From: Simon Davis
Sent: 29 January 2019 10:54
To: Planning.Responses
Subject: FW: BR/281/18/PL 99 Victoria Drive, redevelopment with flats
Attachments: Prop South East Elevation 1.pdf; Prop South West Elevation 1.pdf; Prop North East Elevation 1.pdf; Prop North West Elevation 1.pdf

From: Simon Davis [REDACTED]
Sent: 24 January 2019 13:22
To: 'tim@rodwayplanning.co.uk' [REDACTED]
Subject: RE: BR/281/18/PL 99 Victoria Drive, redevelopment with flats

PROPOSED NORTH EAST ELEVATION

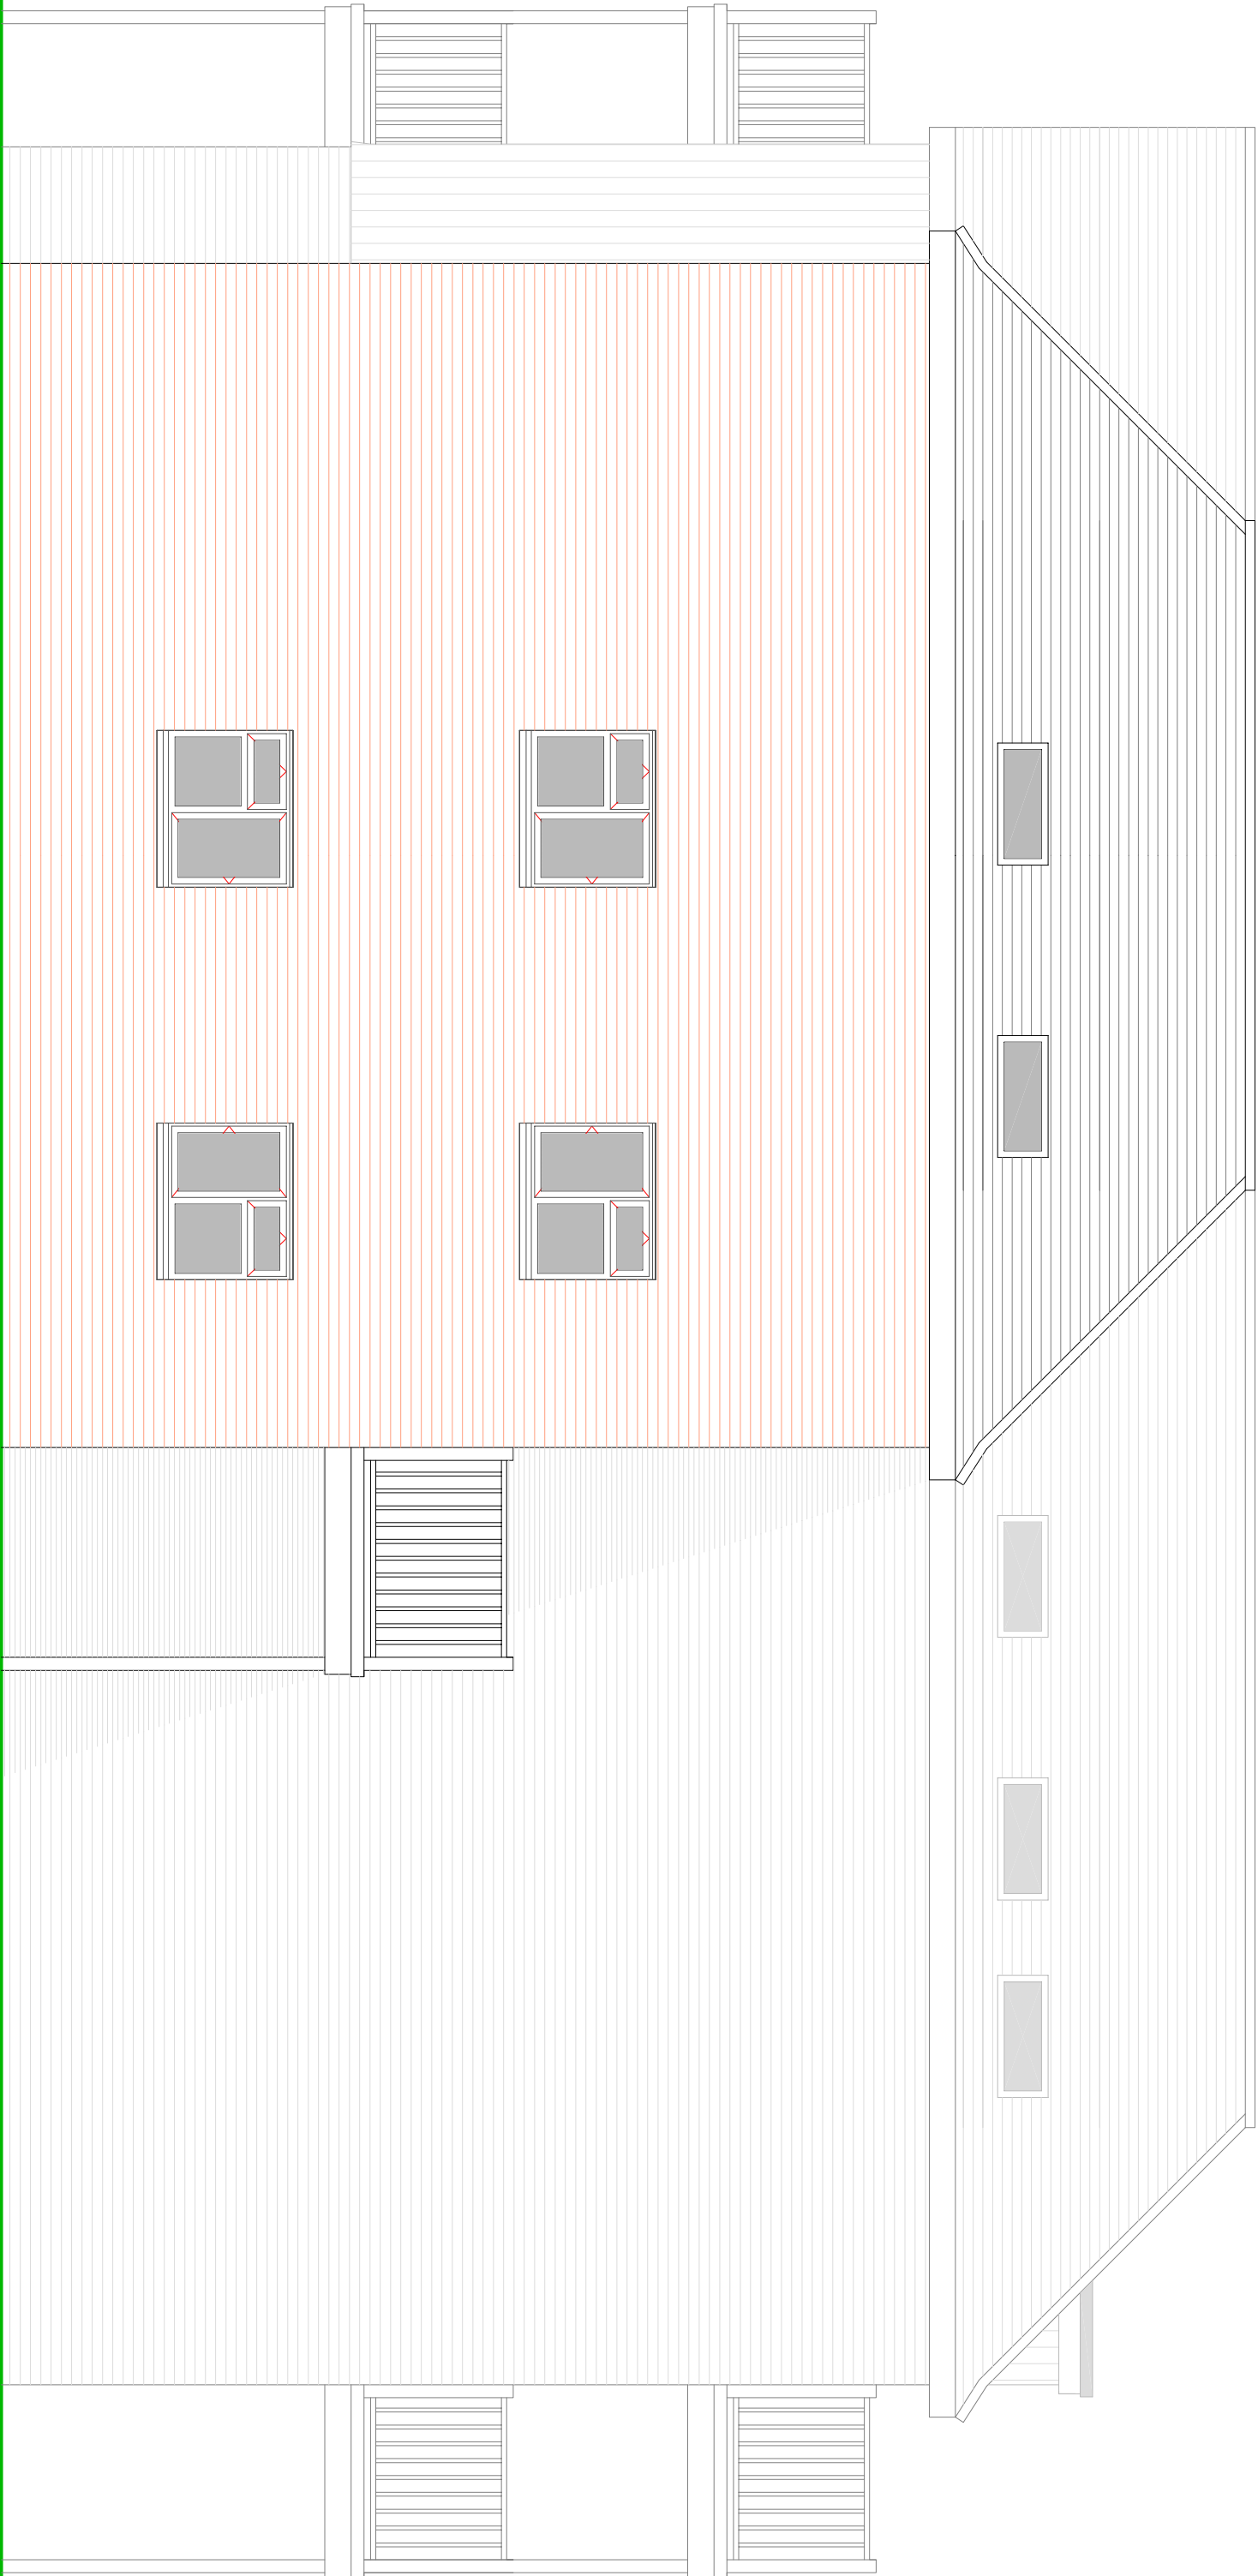
Firstly, we will require that the sides of the rear balconies (including the NE facing side of the balcony to flat 5) be fitted with privacy screens up to 1.7m height – either solid material or o/g glass). Can you provide amended drawings to show this.

Secondly, I will likely require that all first & second floor flank windows be o/g and fixed shut up to 1.7m from the floor level. I note that all of these proposed flank windows are secondary in nature so don't consider this to be a problem but can you advise whether you can agree to this. I note that there was a condition attached to the permission for the flats at 101 (BR/155/06/) that all flank windows were to be o/g so consider there to be precedent for my request. If you agree, can you provide amended drawings to indicate this.

Specifically, the scheme's architect has amended the elevations to show higher screens to the rear side facing guarding of the balconies and added the notes about the glazing to side facing upper floor windows.
